DEVELOPMENT REVIEW BOARD
SUPPLEMENTAL SUBMITTAL

PROJECT NO. 2022-006547

DESCRIPTION: DRB - Site planning 2nd resubmittal city comments response

RE: Panda Express – S8-22-D8582
10126 Coors Blvd. NW
Albuquerque, NM 87114
RE: DRB Planning Review – 2nd Resubmittal
DRB Project Number: 2022-006547
App. Number: SI-2022-00216

A-100b

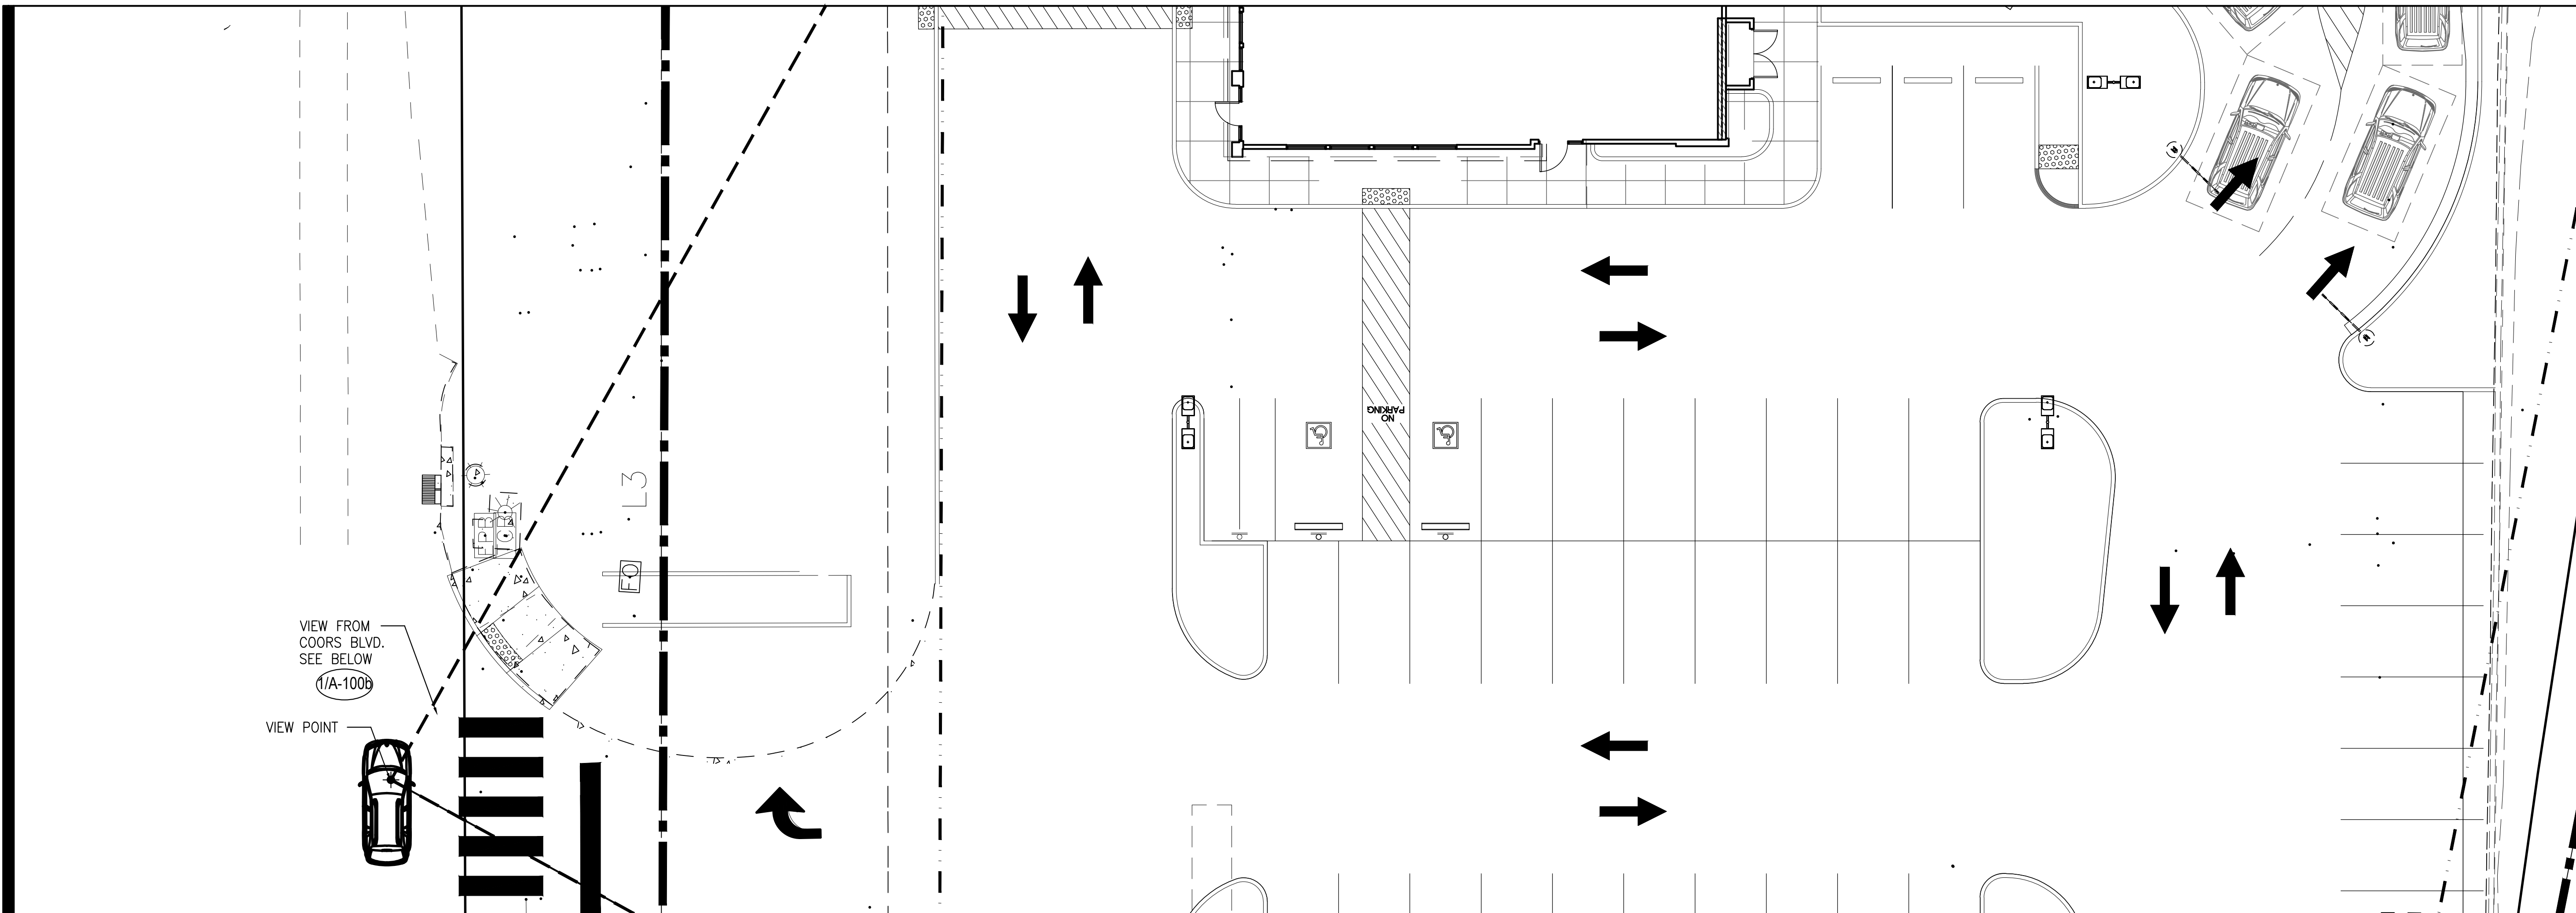
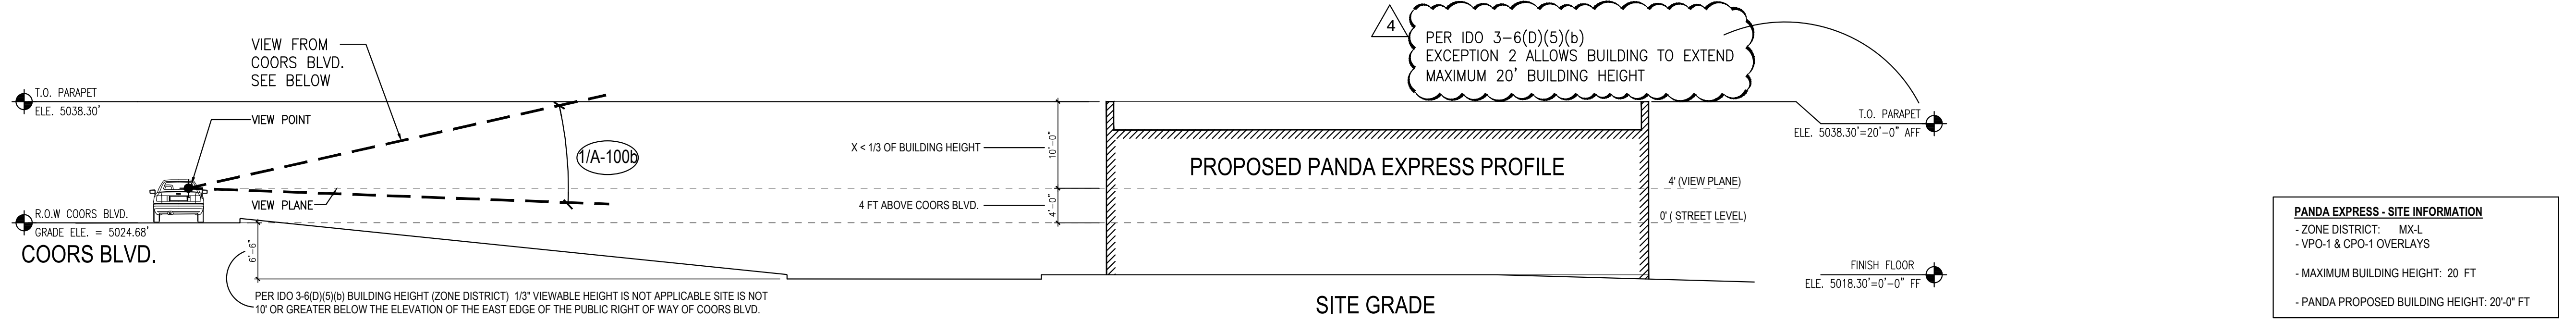
- Updated 4/4/22 – The parcel lies within the Coors Boulevard View Protection Overlay. The construction of a new building in a new location triggers the View Protection Analysis requirements of 3-6(D)(5)(b) Building Structure height, Bulk and Massing (View Plan) wherein no more than 1/3 of the height of buildings and structures may penetrate the view plan. The second test is 5-6(D)(5)(c) Building and Structure Bulk (View Frame). No more than 50% of the area in the view frame can be obscured by the bulk of the building and no portion of the building shall extend above the ridgeline of the Sandia mountains (Full detail in the IDO is given for this analysis)

Response: Drawings have been updated refer detail 1, 3 and 13/A-100 for overlay analysis of overlay.

C03.2

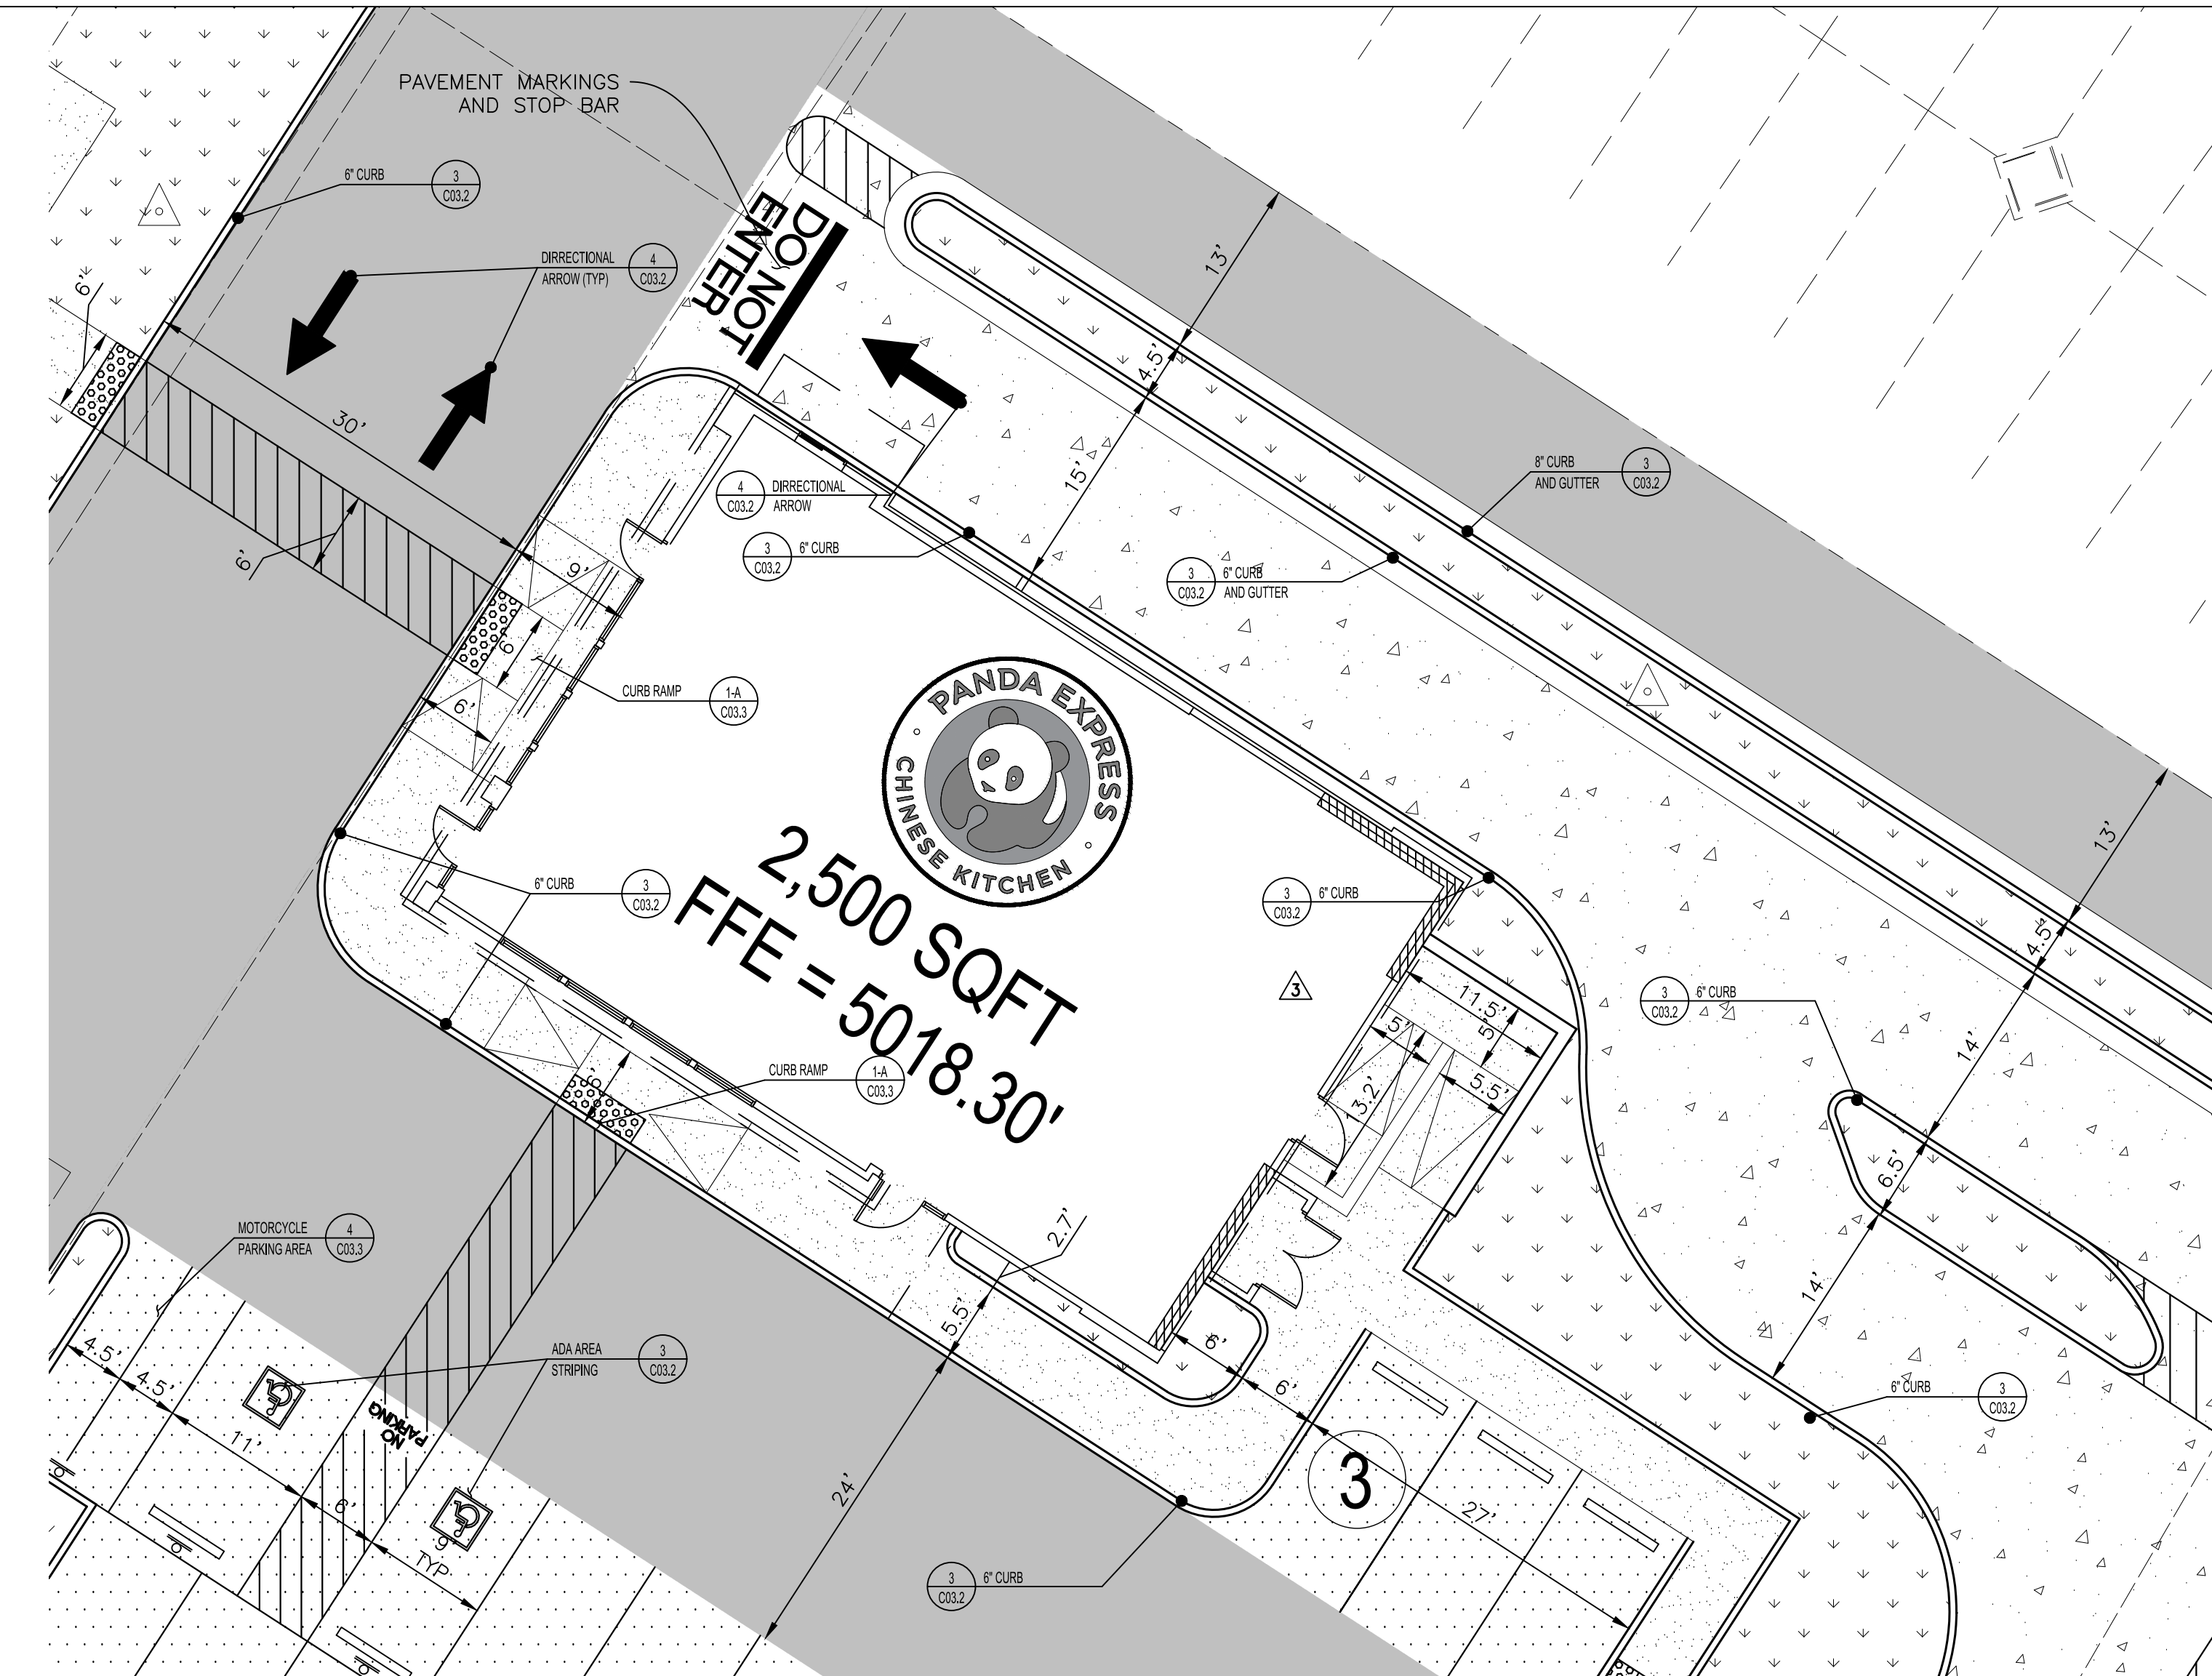
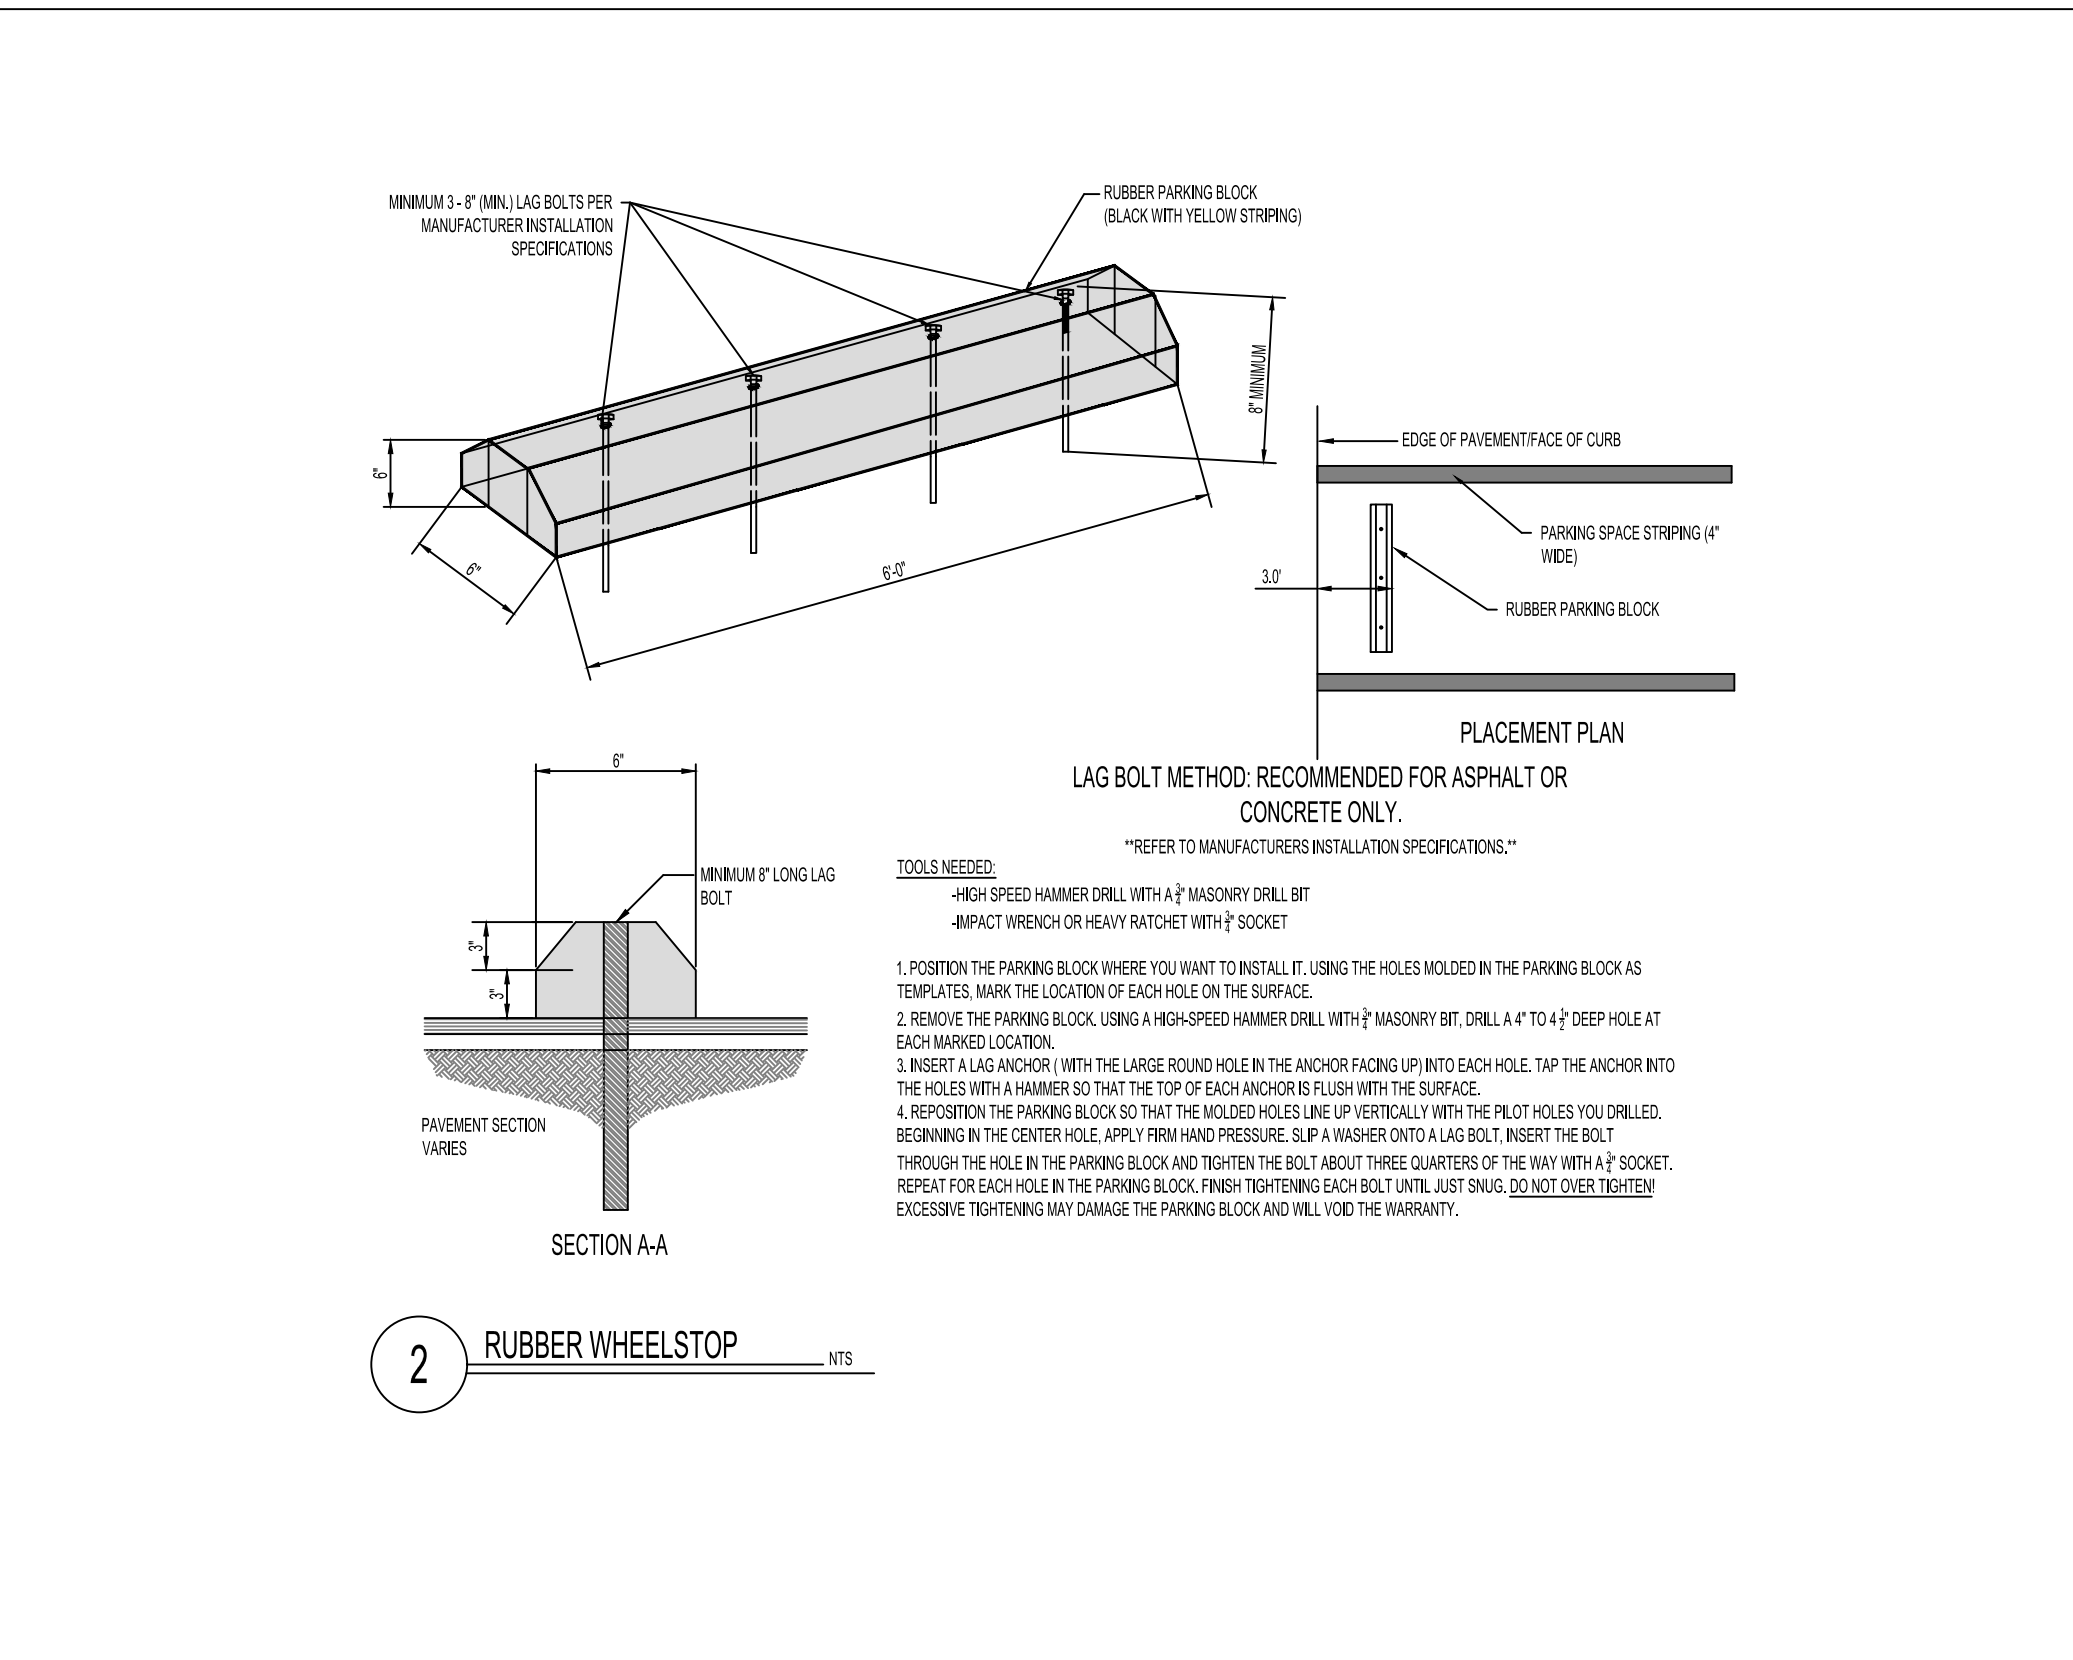
7. The ADA accessible parking sign must have the required language per 66-7-352.4C NMSA 1978 “**Violators Are Subject to a Fine and/or Towing.**” If that language is present it is not visible in the detail.

8. Motorcycle and bicycle parking details are needed. These shall include bike rack details and motorcycle parking signage details.

Response: Noted, see updated detail 5 on sheet C03.2

Response: Noted, see detail 4 on sheet C03.3 and detail 1 on sheet C03.4 SIGN
